### **Final Report - Corrections Required** **Application No. ANEX-24-0003**

**Description : Matrix Design Group on behalf of Colorado Springs Equities LLC is submitting a serial annexation petition for seven parcels and Land Use Plan/Rezoning exhibit for a portion of the subdivision known as Rock Creek Mesa.**

**Document Filename : 224.023-SURV-RCM ANNEX PLAT 3.pdf**

## ROCK CREEK MESA ADDITION NO. 3

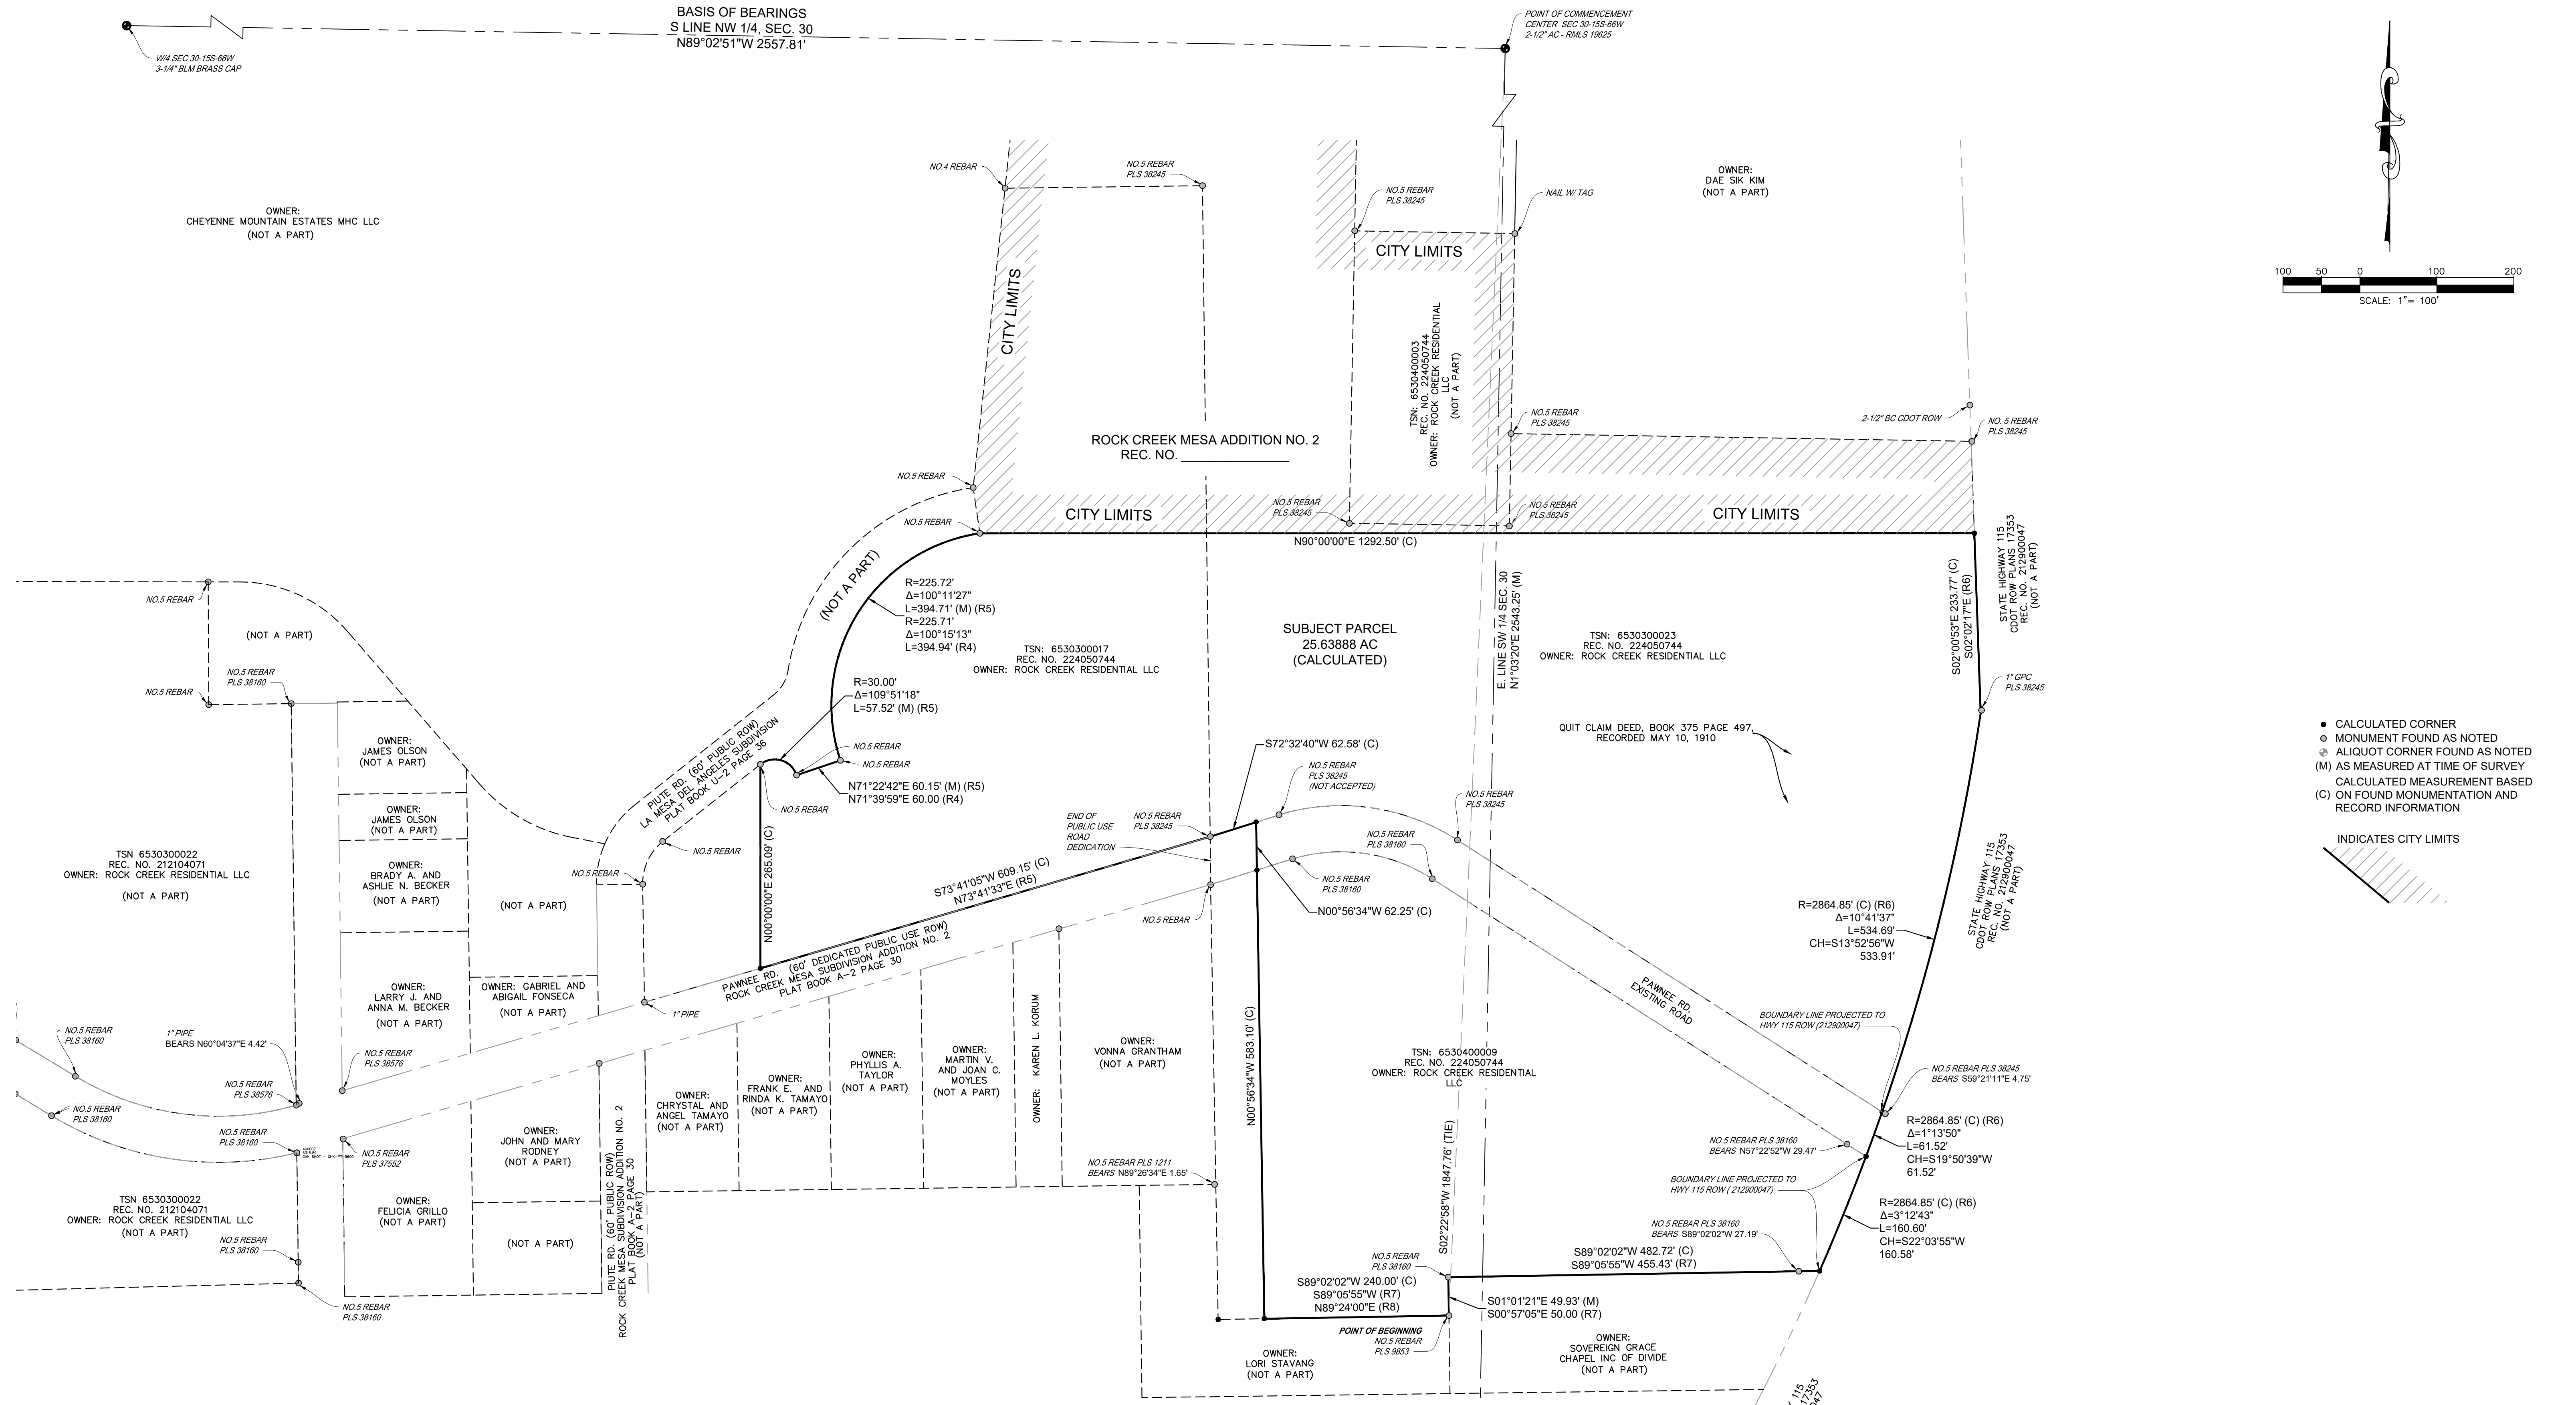
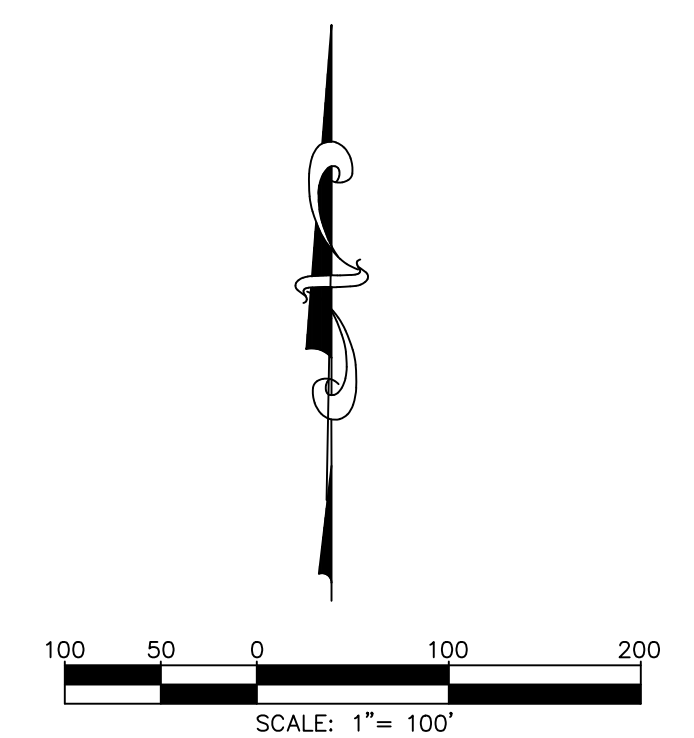
23	2	Cory Sharp : Planning	Please remove the areas from all adjacent parcels
24	2	Cory Sharp : Planning	Please add a label for Rock Creek Mesa Addition No. 2
25	2	Cory Sharp : Planning	Please add a label for Rock Creek Mesa Addition No. 1
26	2	Cory Sharp : Planning	Please check/revise the bearing and distance S89-02-57E 208.00' legal description
27	2	Cory Sharp : Planning	Please add (M) and (C) to the legend
28	2	Cory Sharp : Planning	Please label what this line represents

<b>Comment ID</b>	<b>Page Reference</b>	<b>Reviewer : Department</b>	<b>Review Comments</b>
29	2	Cory Sharp : Planning	Please remove Rock Creek Mesa Addition No. 3
30	2	Cory Sharp : Planning	It would be helpful to change the text style of the ownership information so that it is clearly informational text
31	2	Cory Sharp : Planning	Please reverse the bearing S90-00-00W to match the legal description

ANNEXATION PLAT
ROCK CREEK MESA ADDITION NO. 3

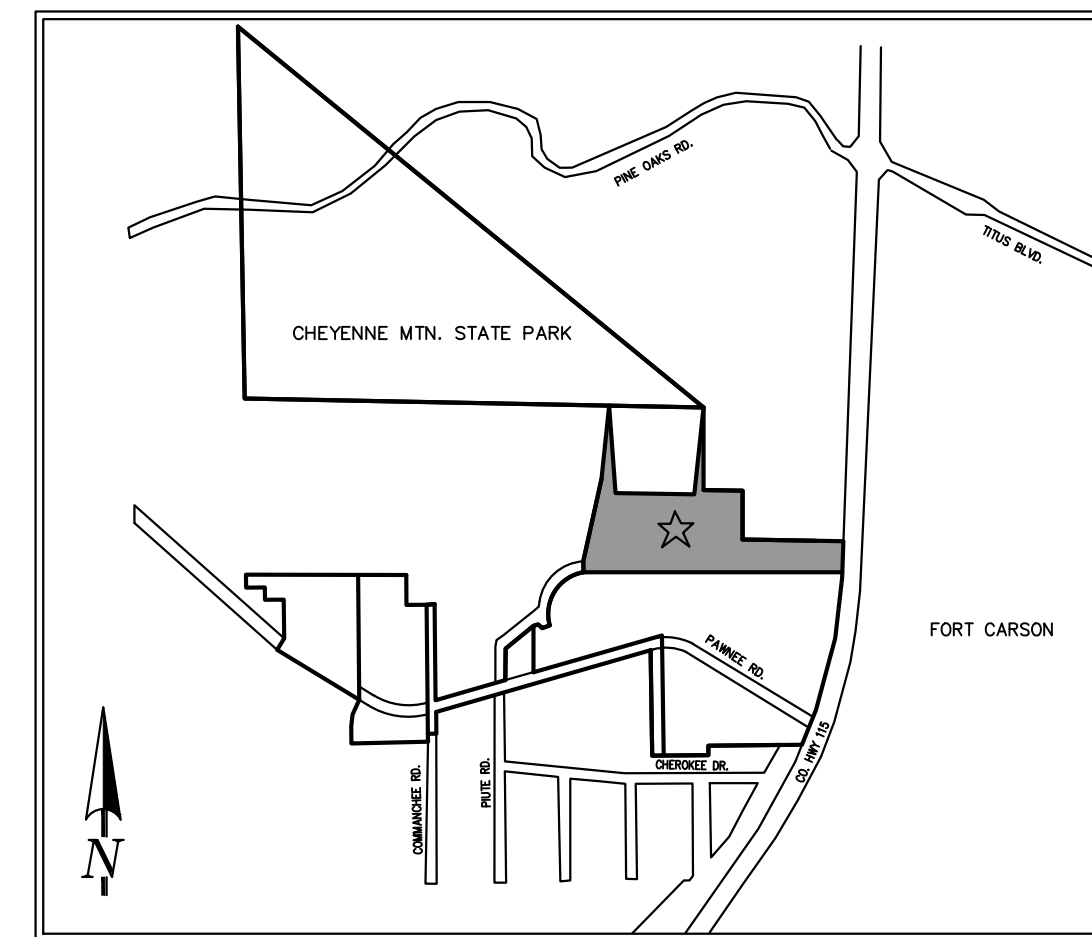
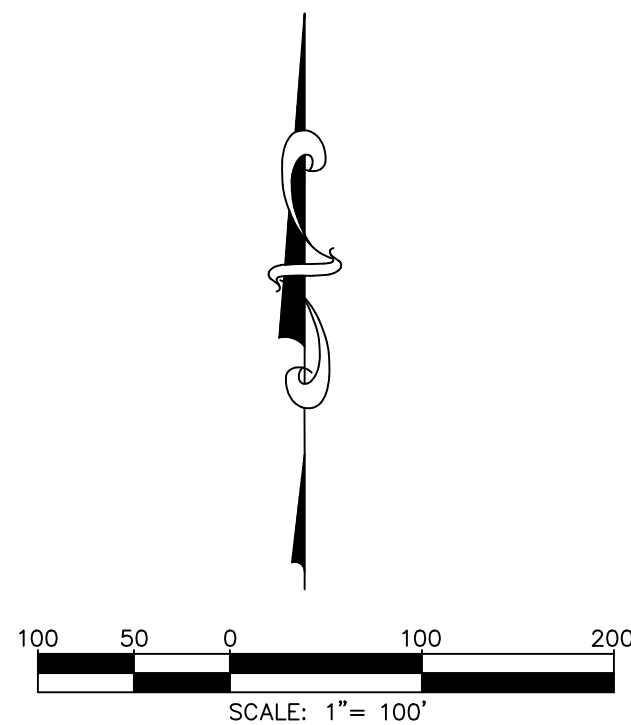
16	1	Gabe Sevigny : Planning	Update to ANEX-24-0003
17	1	Cory Sharp : Planning	Please add the area at the end of the legal description
18	1	Cory Sharp : Planning	<p>Please update 3, 4 &amp; 5 to the following contiguity statement:</p> <p>contiguity statement:</p> <p>Total Perimeter of the Area for Annexation: 5,026.32' One-Fourth (1/4th) of the Total Perimeter: 1,256.58' (25.00%) Perimeter of the Area Contiguous to the Existing City Limits: 1,263.76' (25.14%)</p>
19	1	Cory Sharp : Planning	Please add quotations around the plat name "Rock Creek Mesa Addition No. 3"
20	2	Cory Sharp : Planning	Please clearly depict all of the city limits not just that adjacent portion
21	2	Cory Sharp : Planning	Please clearly label the adjacent areas *not a part* for clarity
22	2	Cory Sharp : Planning	It would be easier for review if the adjacent areas were a dashed line type instead of solid line type please review and adjust accordingly

Please add quotations around the plat name "Rock Creek Mesa Addition No. 3"
